Application No: BE/46/21/PL
Site Address: 1 Sunningdale Gardens Bersted PO22 9LE
Description of works: Side and rear extension and divide into 2 No. 2 bed properties.

Thank you for your internet representation made on 4th August 2021 which has been recorded as an objection with the comments as follows:

: OBJECT for the following: -

Proposed Ground Floor Plan

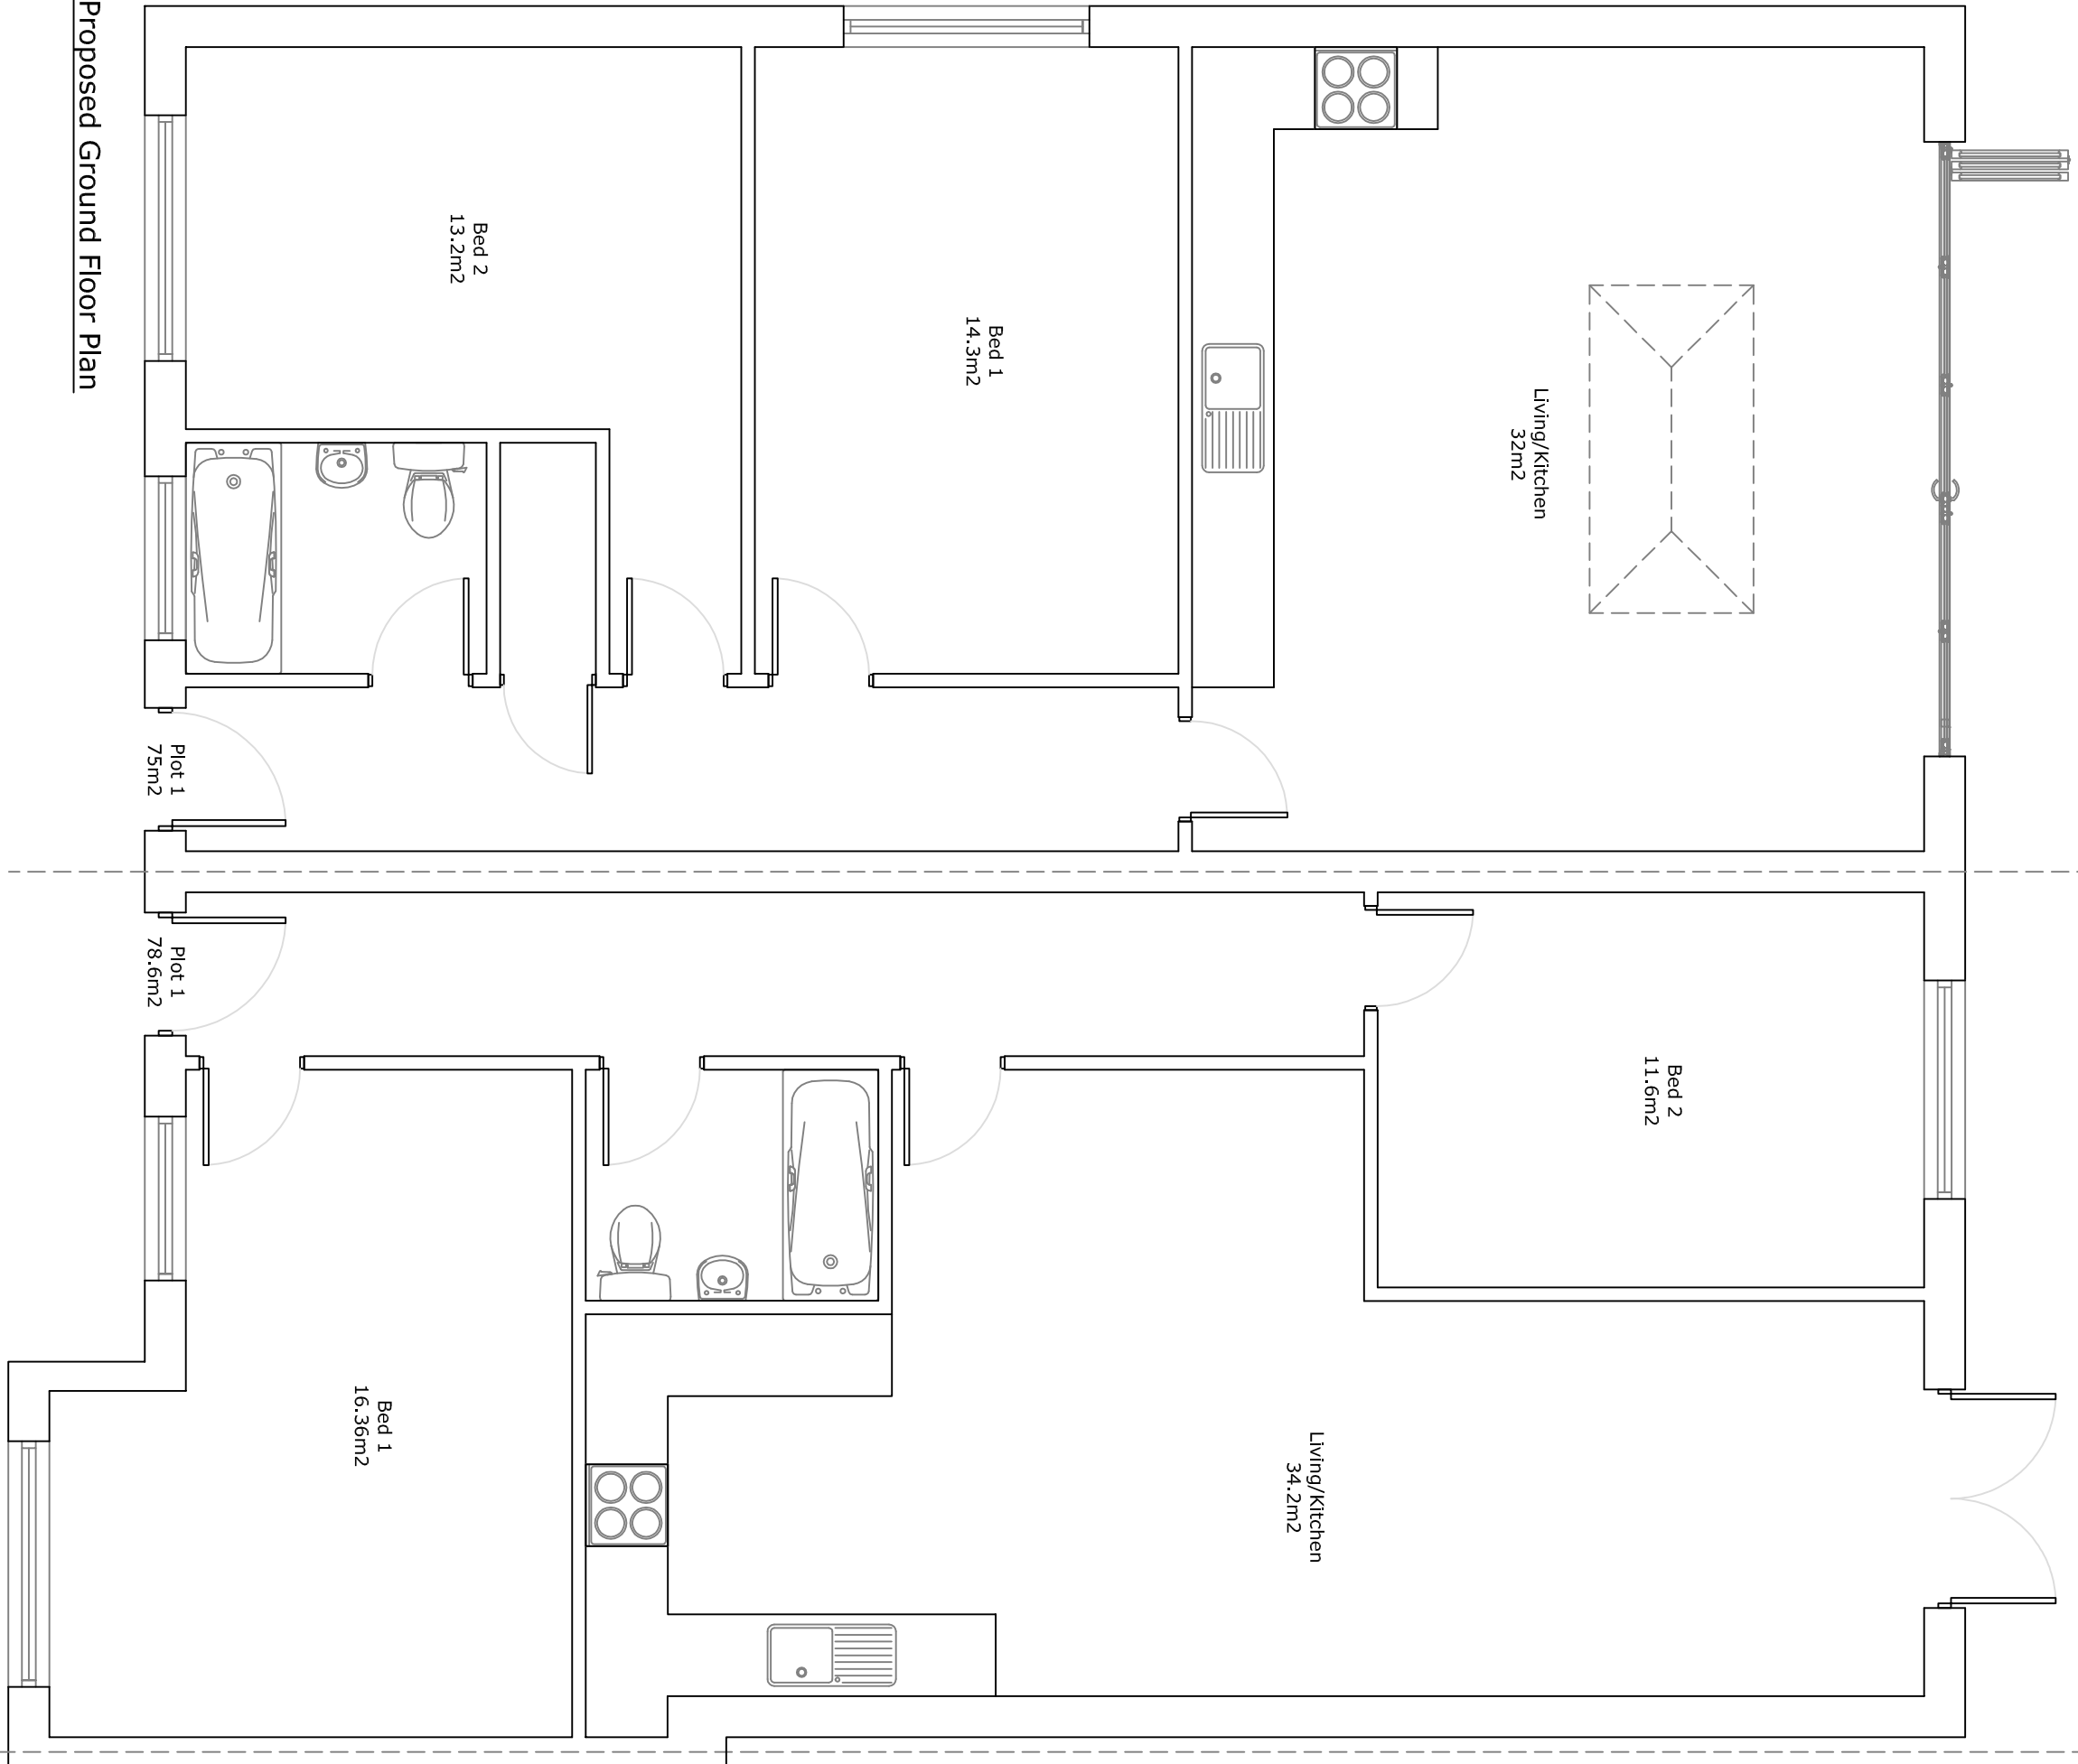
The proposals are an overdevelopment and are built over the building line and is contrary to Arun Local Plan policies DDM1 and DDM4.

There are concerns for Highway safety with cars accessing and egressing this proposed extension on the junction with Rowan Way.
